**Consultation Response from KC,
Trees**
2024/92281 Land adj, 17, Whitehall Road West, Birkenshaw, BD11 2LS
Erection of 23 dwellings
Date Responded: 05/09/2024
Responding Officer: JD
Responding Ref: 03/18

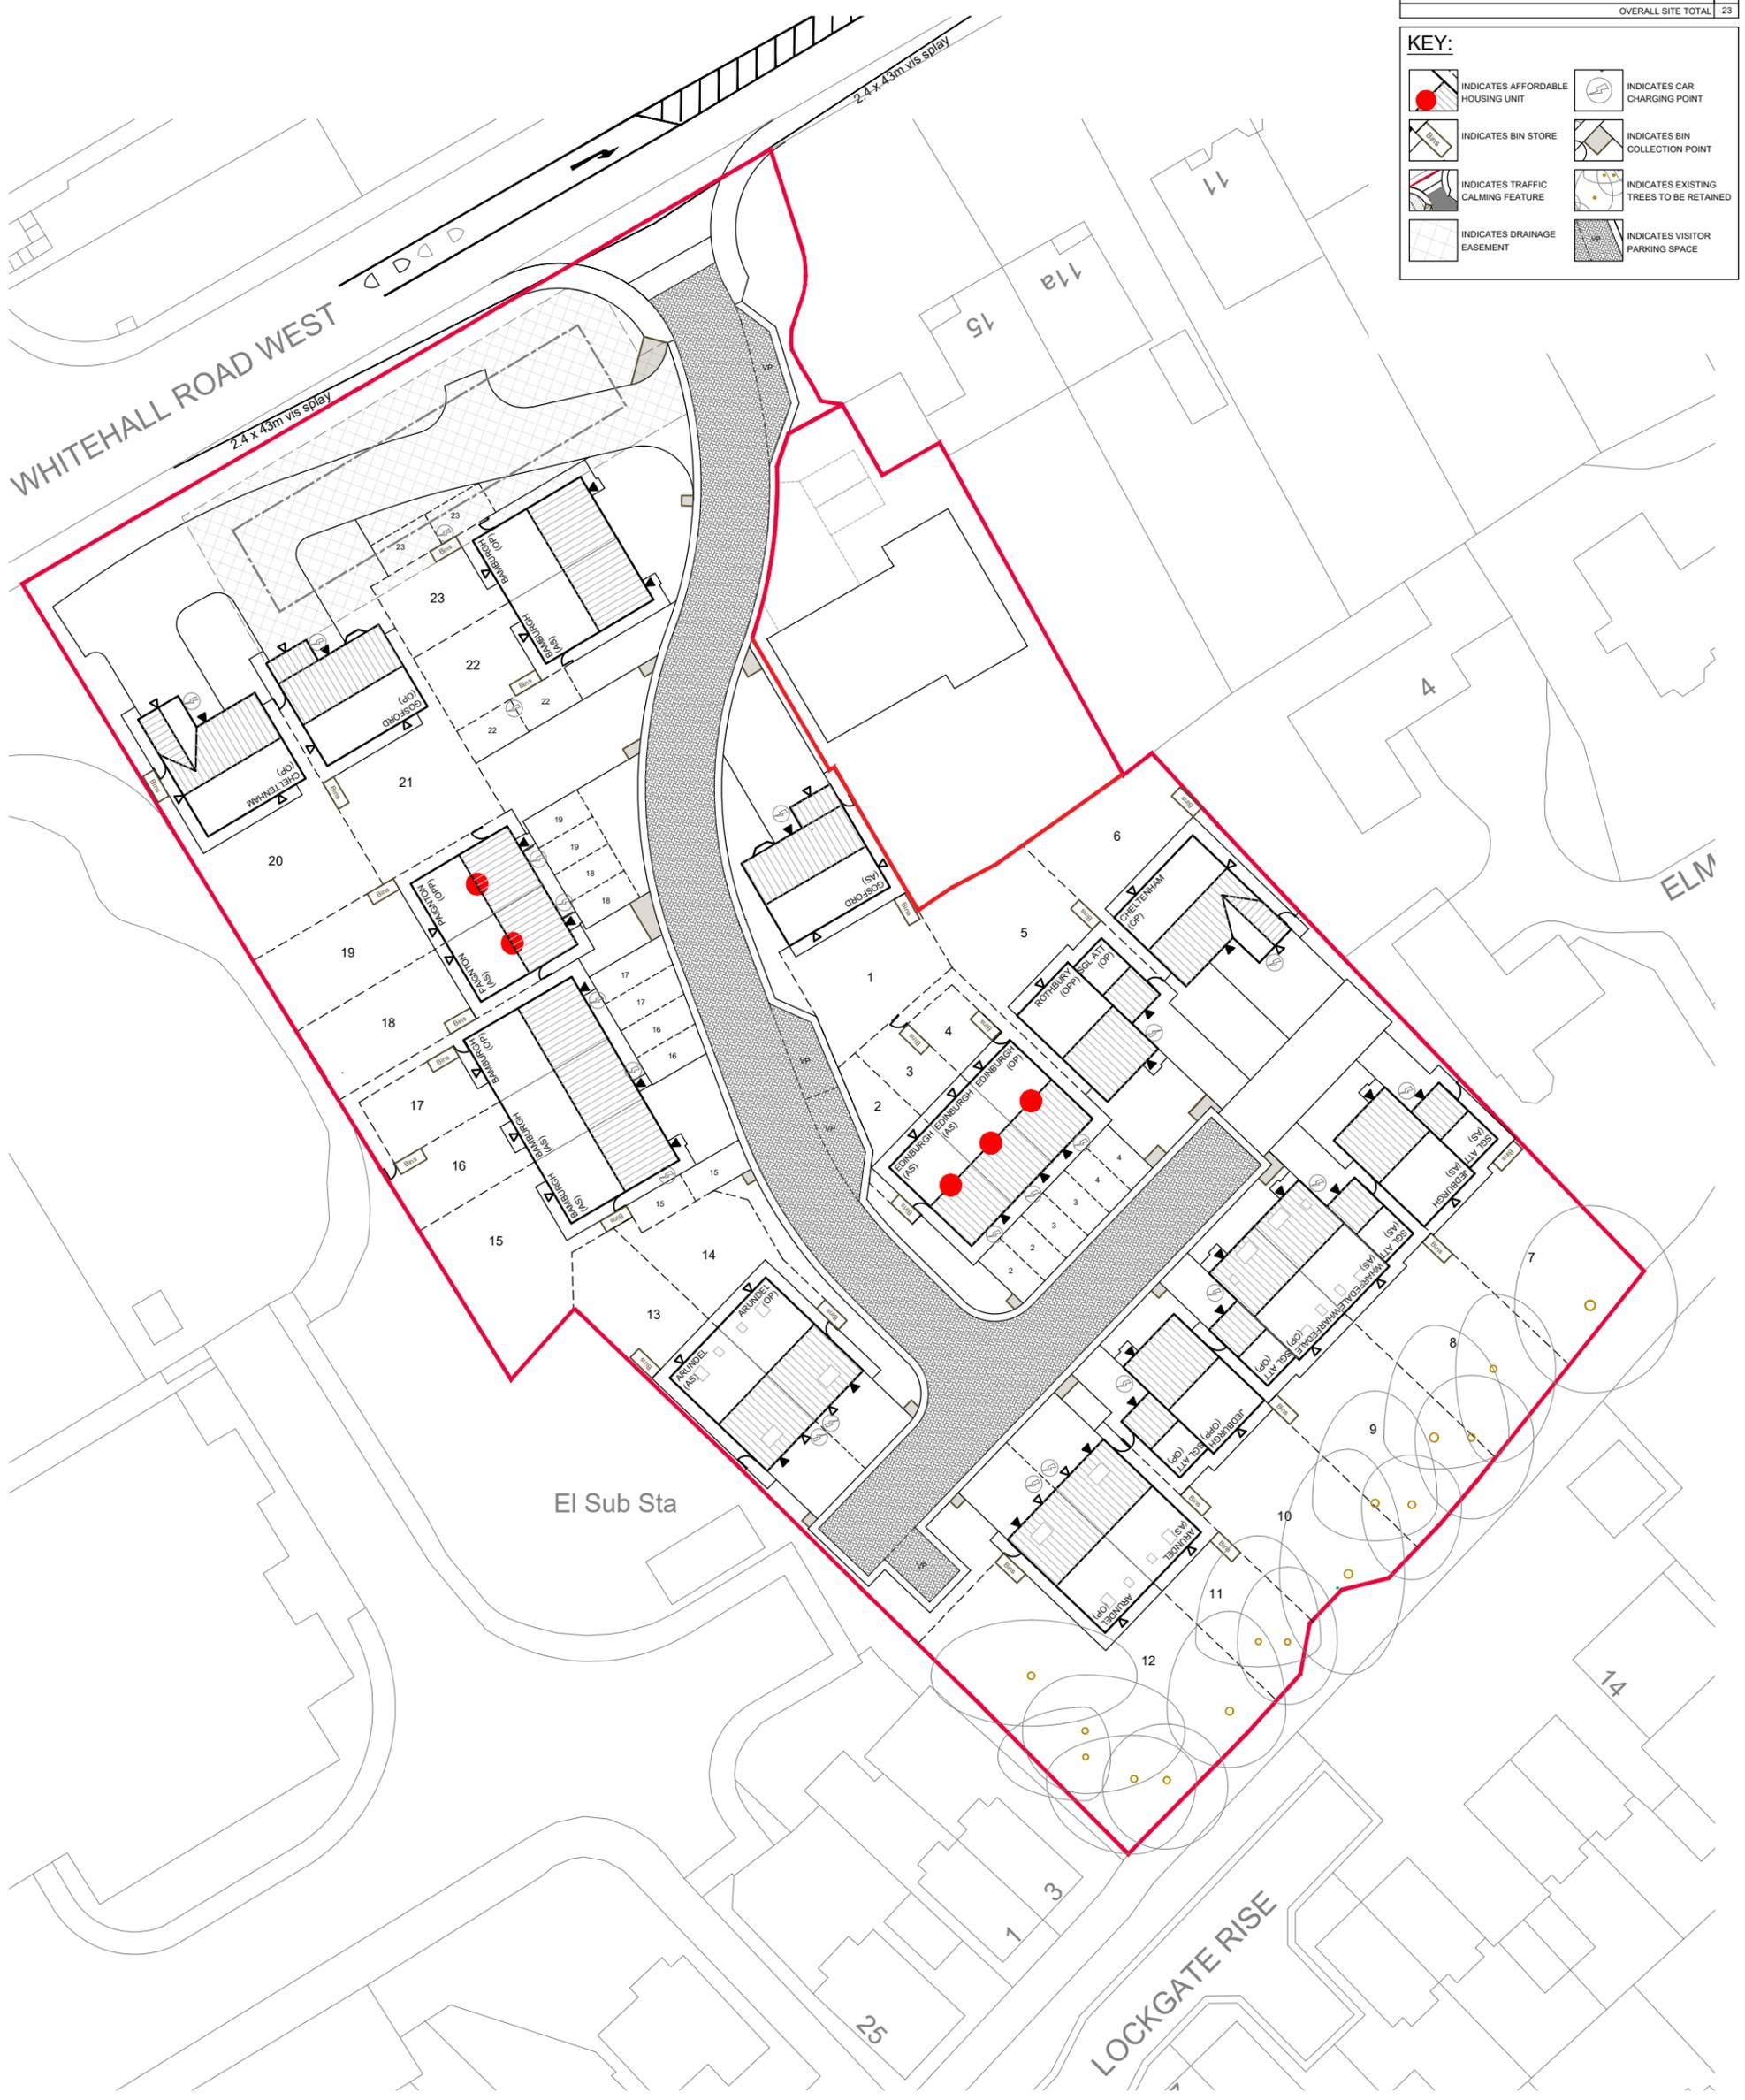
From a desk based assessment the site appears to be heavily constrained by tree. It also has some trees protected under TPO 03/18 to the southern boundary.

There has been no Arboricultural information submitted with the application and therefore it is impossible to make a judgement of the proposals impact on the surrounding trees. As it currently stands there appears to be a large amount of tree loss to facilitate the development.

An arboricultural impact assessment (AIA) and an arboricultural method statement (AMS) would be required to provide more detail with regard to tree loss and impact as well as tree protection during construction.

There is a **holding** objection from a trees perspective. The proposal conflicts with adopted Kirklees local plan policy 33 and 24 (i)
